Subject: Callout
Page Index: 10
Date: 12/5/2023 4:31:04 PM
Author: Jeff Rice - EPC Engineering Review
Color: ■
Layer:
Space:
Page Label: 10

PROPOSED
DRAINAGE MAP
HECRAS SECTIONS

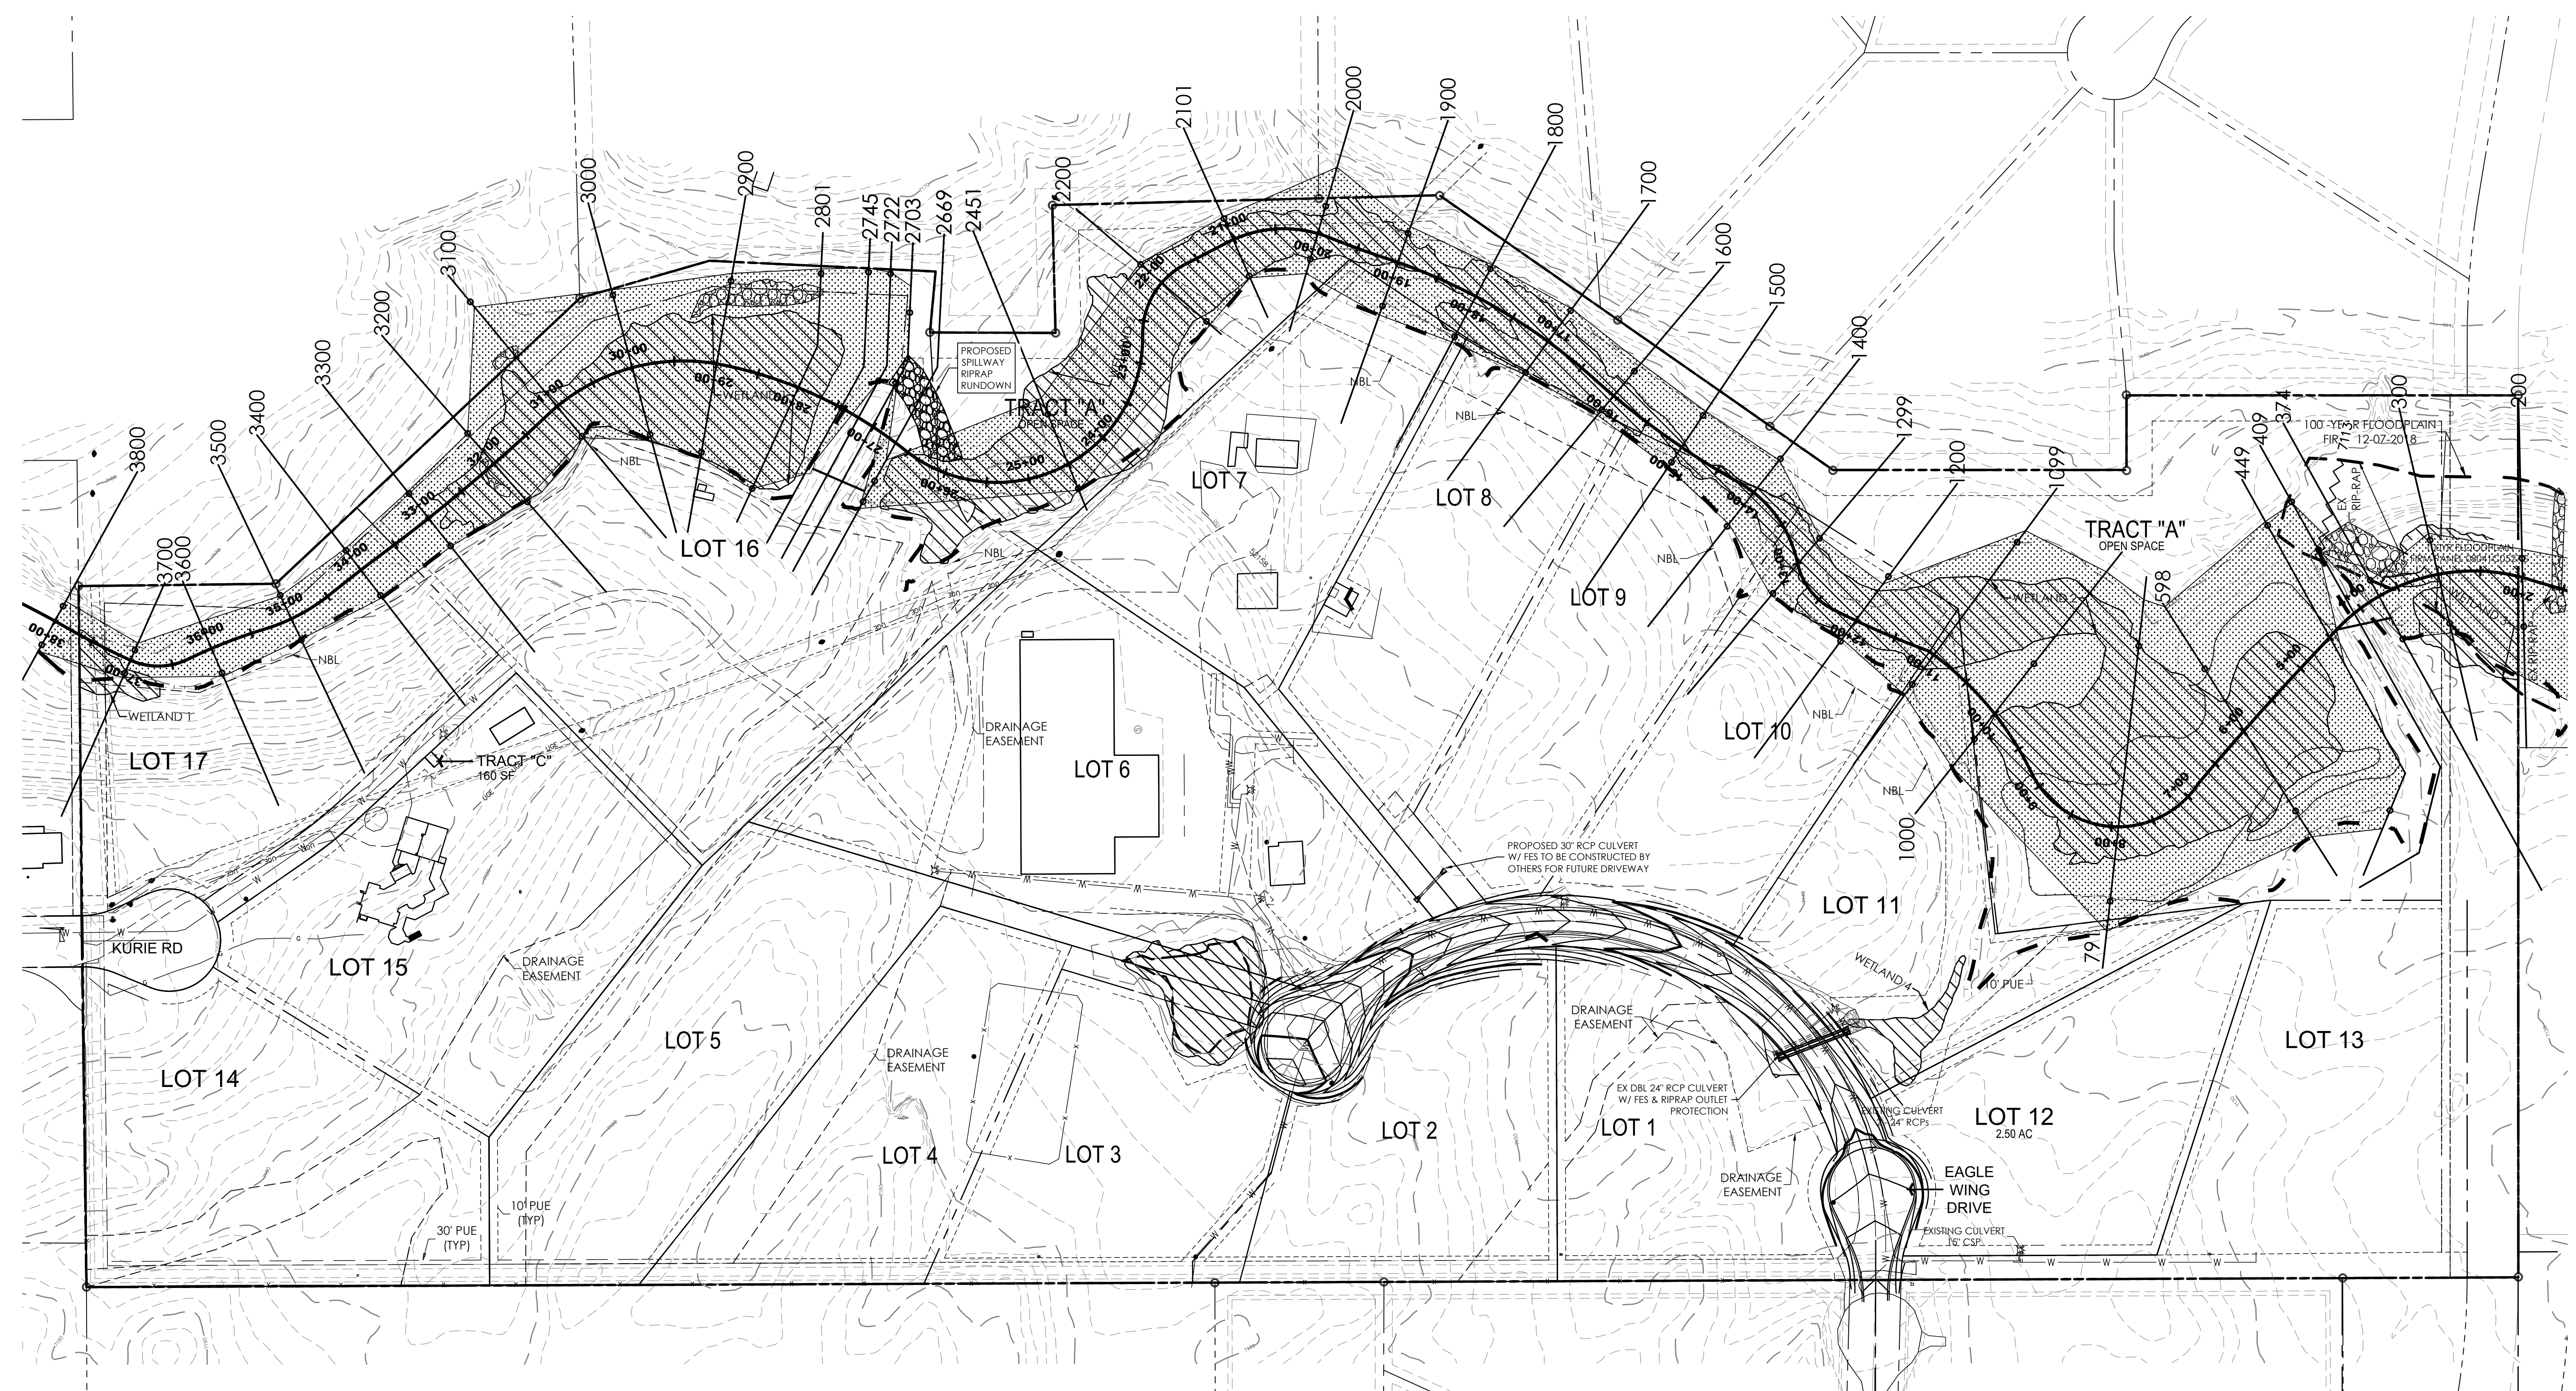
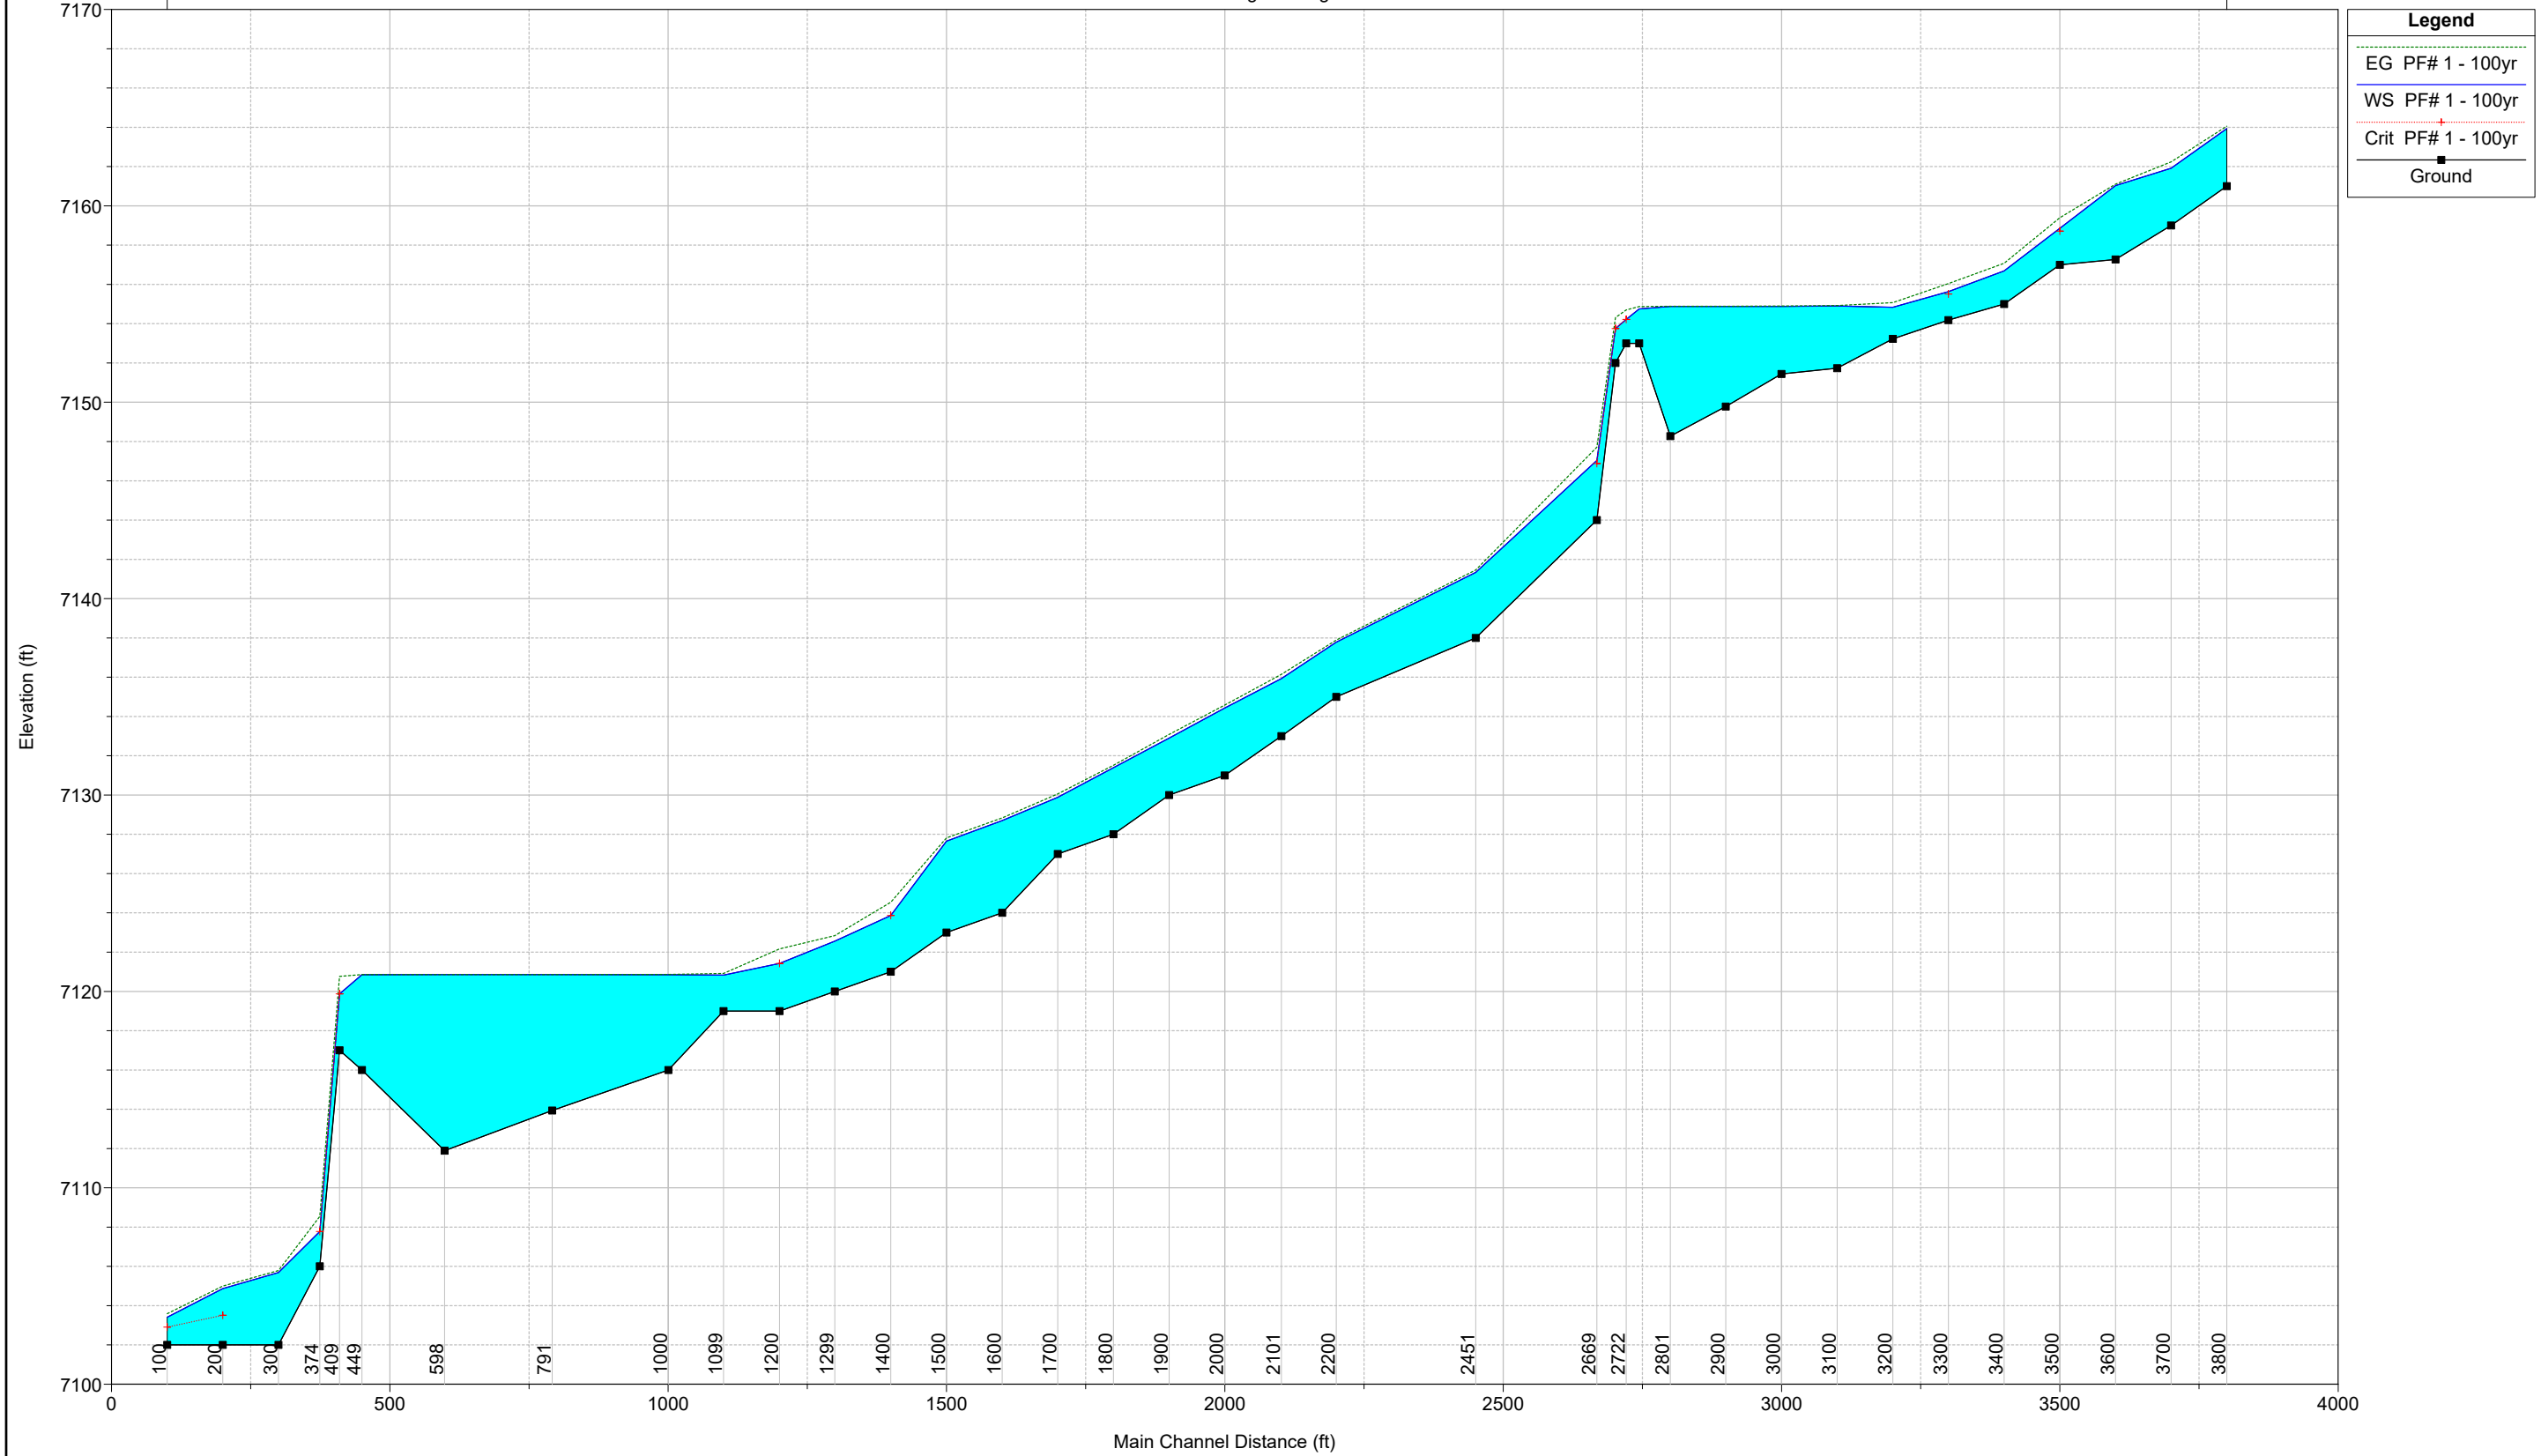
not shown on GEC plan

Missing drainage easement

Label drainage easements or add specific linetype to legend

Drainage easement should include the entire flow area per contours

Provide drainage easement.

Show all drainage easements

Label pond outfall and provide design

Show proposed road contours

Area flows to Basin G?

CREEK ACCESS

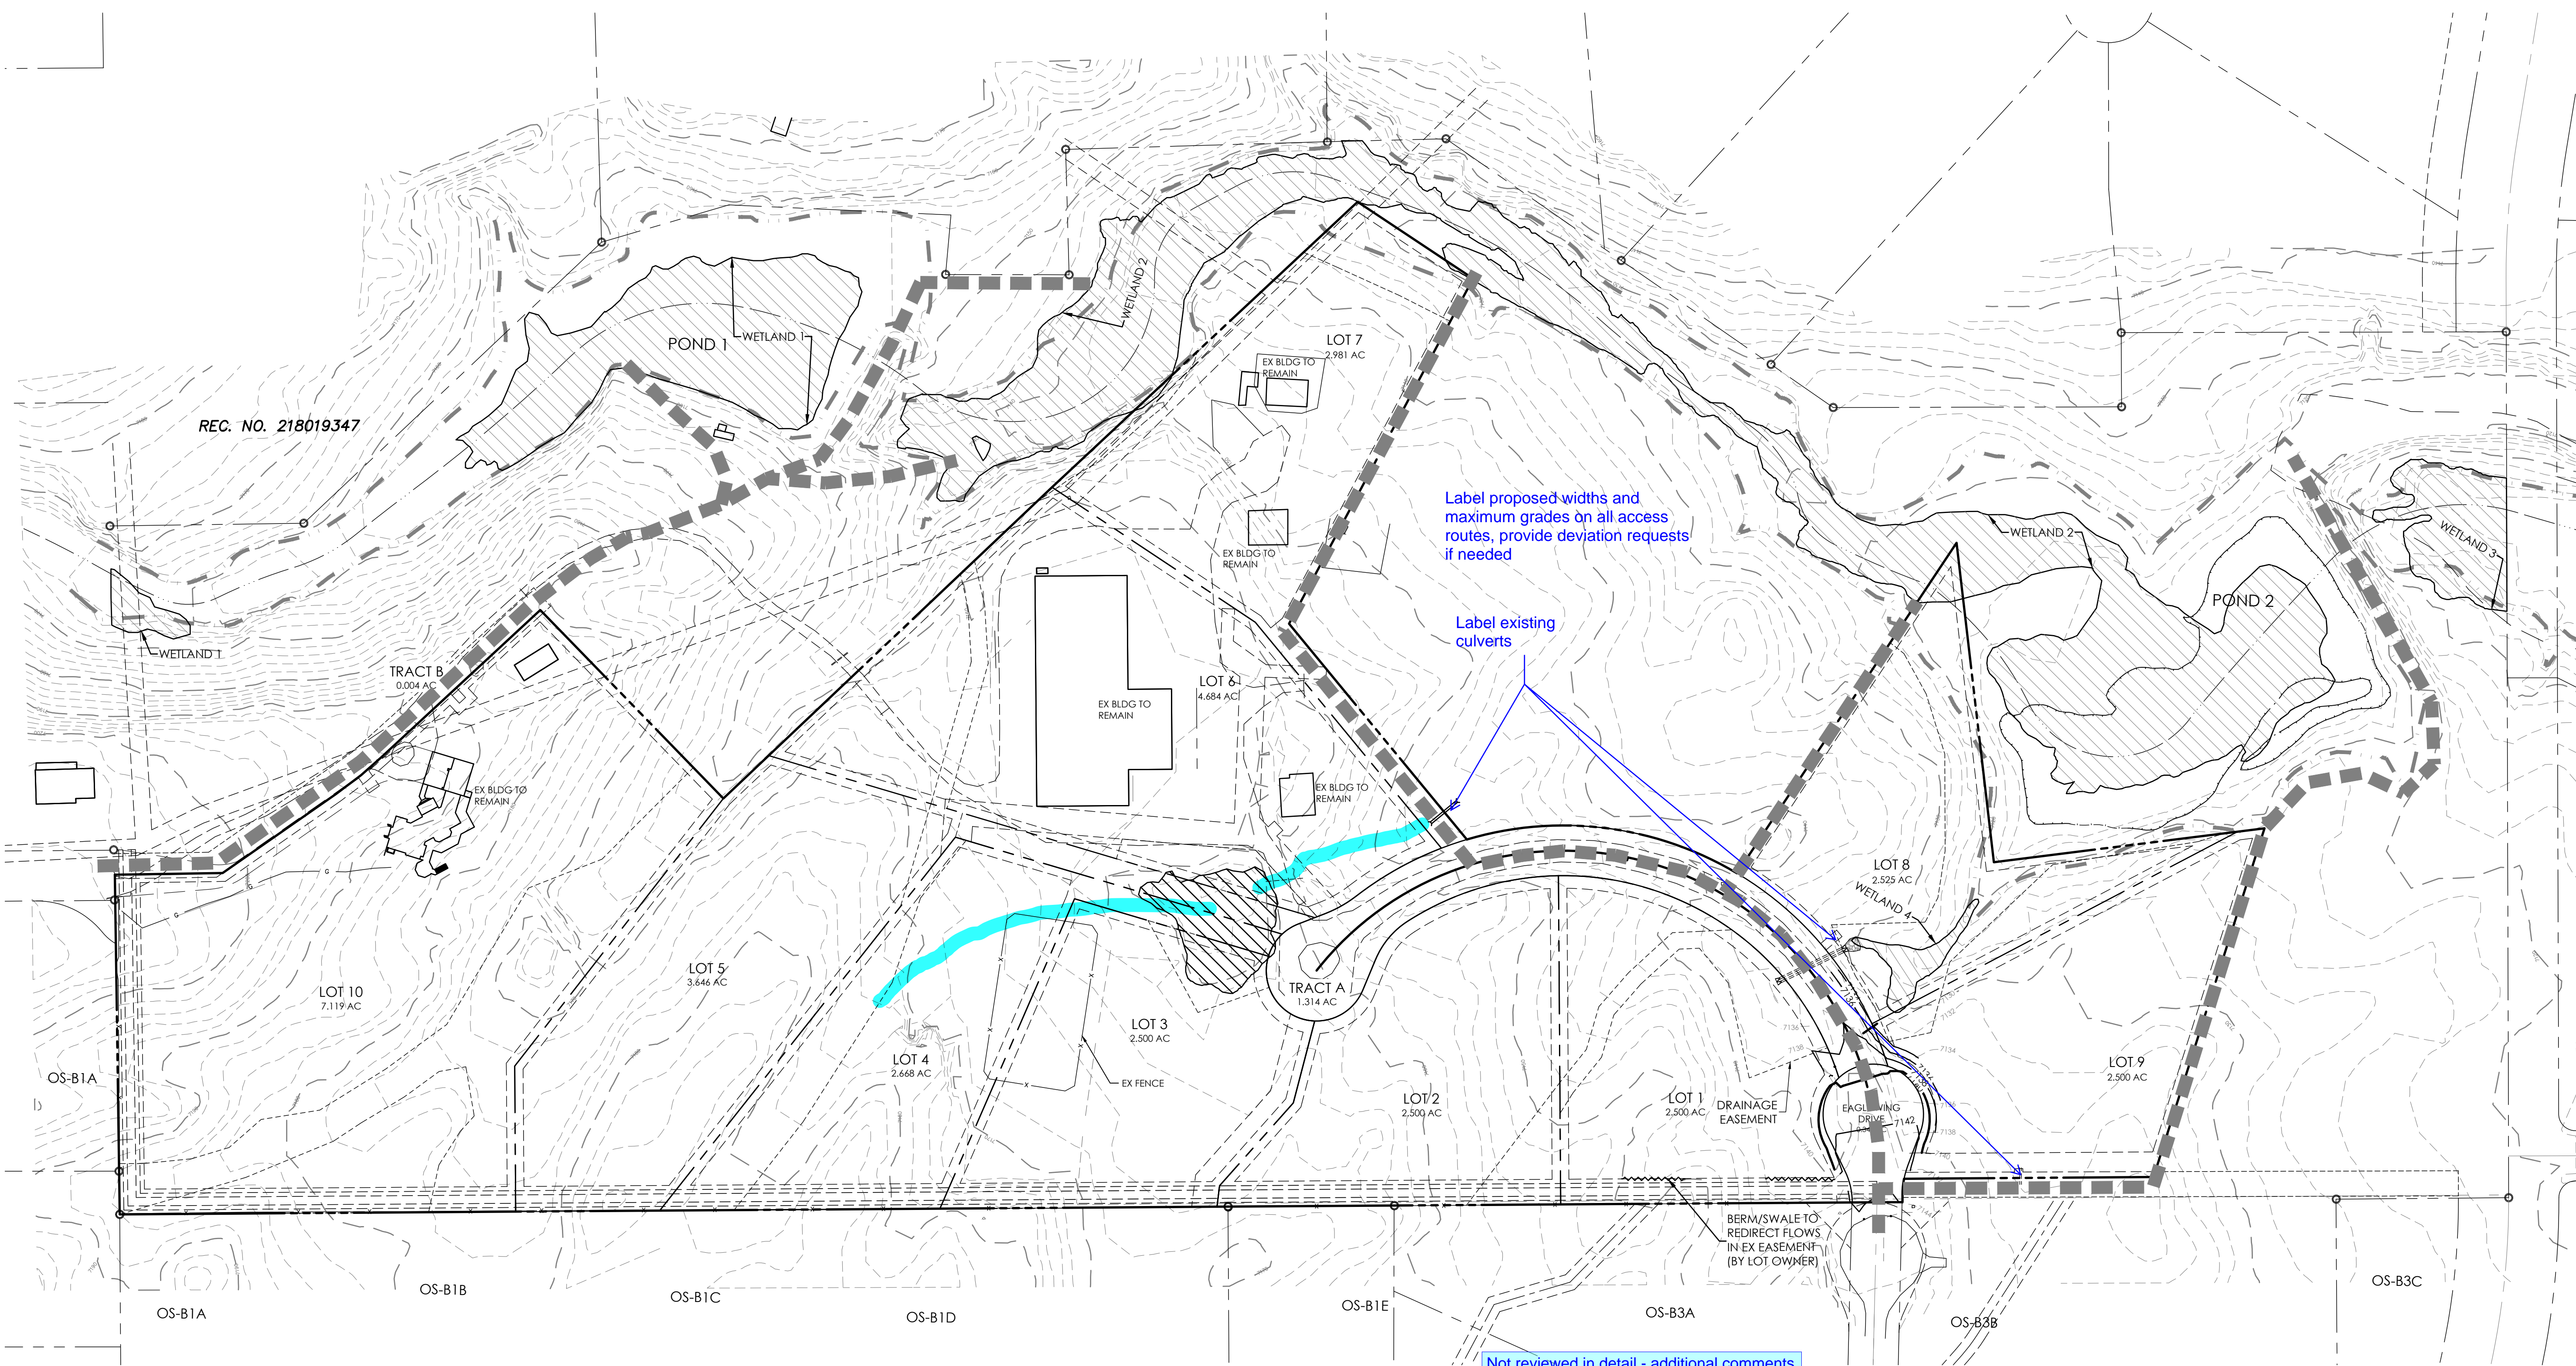
provide exhibit, including where fencing is prohibited
